Re: Pavement Recommendations
Sterling Ranch, Filing No. 2
El Paso County, Colorado

APPROVED
Engineering Department

EPC Planning & Community
Development Department

| AD  | ALZADA DRIVE              |

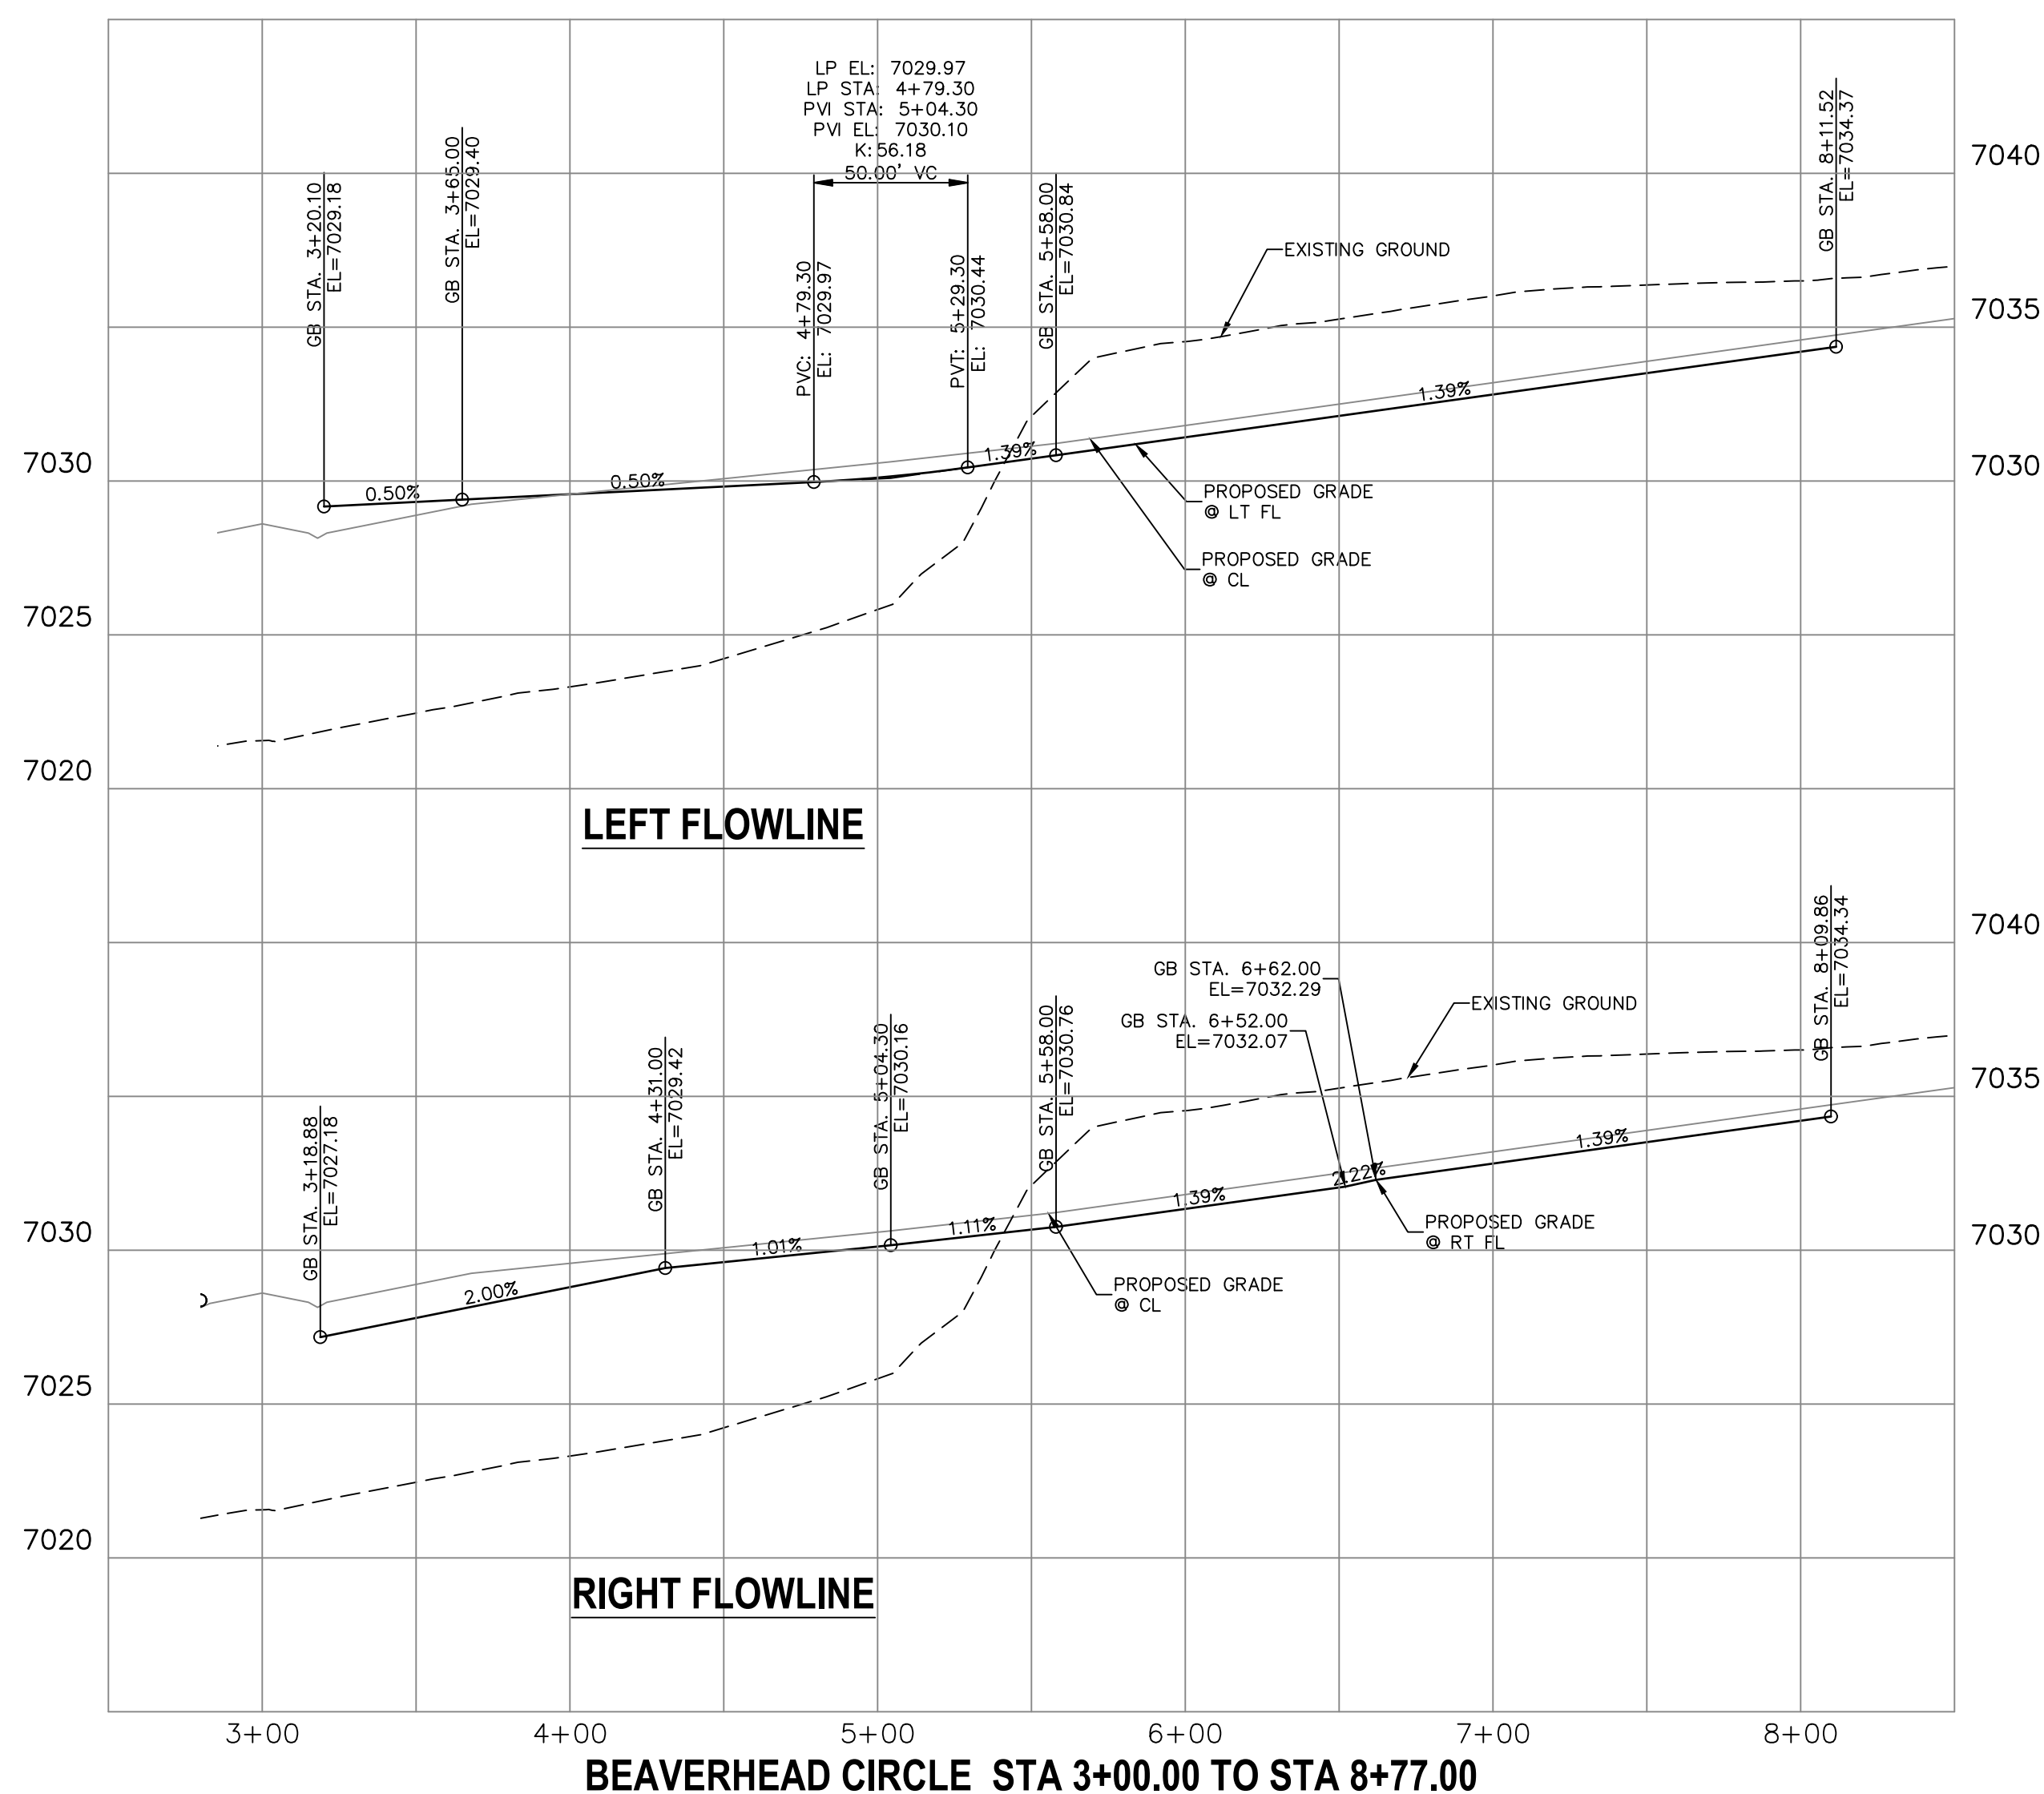
***asphalt millings and full depth
are not acceptable-- EN, PCD**

CBR testing was used to determine pavement sections for the roadway sections. Pavement sections were determined utilizing Pavement Design Criteria for the El Paso County. The cul-de-sac portion of Beaverhead Circle classifies as a local low-volume road, which used an 18k ESAL value of 36,500 for design. Bynum Drive, Cordgrass Drive, and Beaverhead Circle from Alzada Drive to Cordgrass Drive classify as local roads, which used an 18k ESAL volume of 292,000 for design. Alzada Drive classifies as a residential collector, which used on 18K ESAL value of 821,000 for design. Pavement sections were determined for asphalt supported on aggregate base course, asphalt millings, and on recycled concrete. County approval is required if asphalt millings or recycled concrete are to be utilized. ***asphalt millings and full depth are not acceptable, EN, PCD**
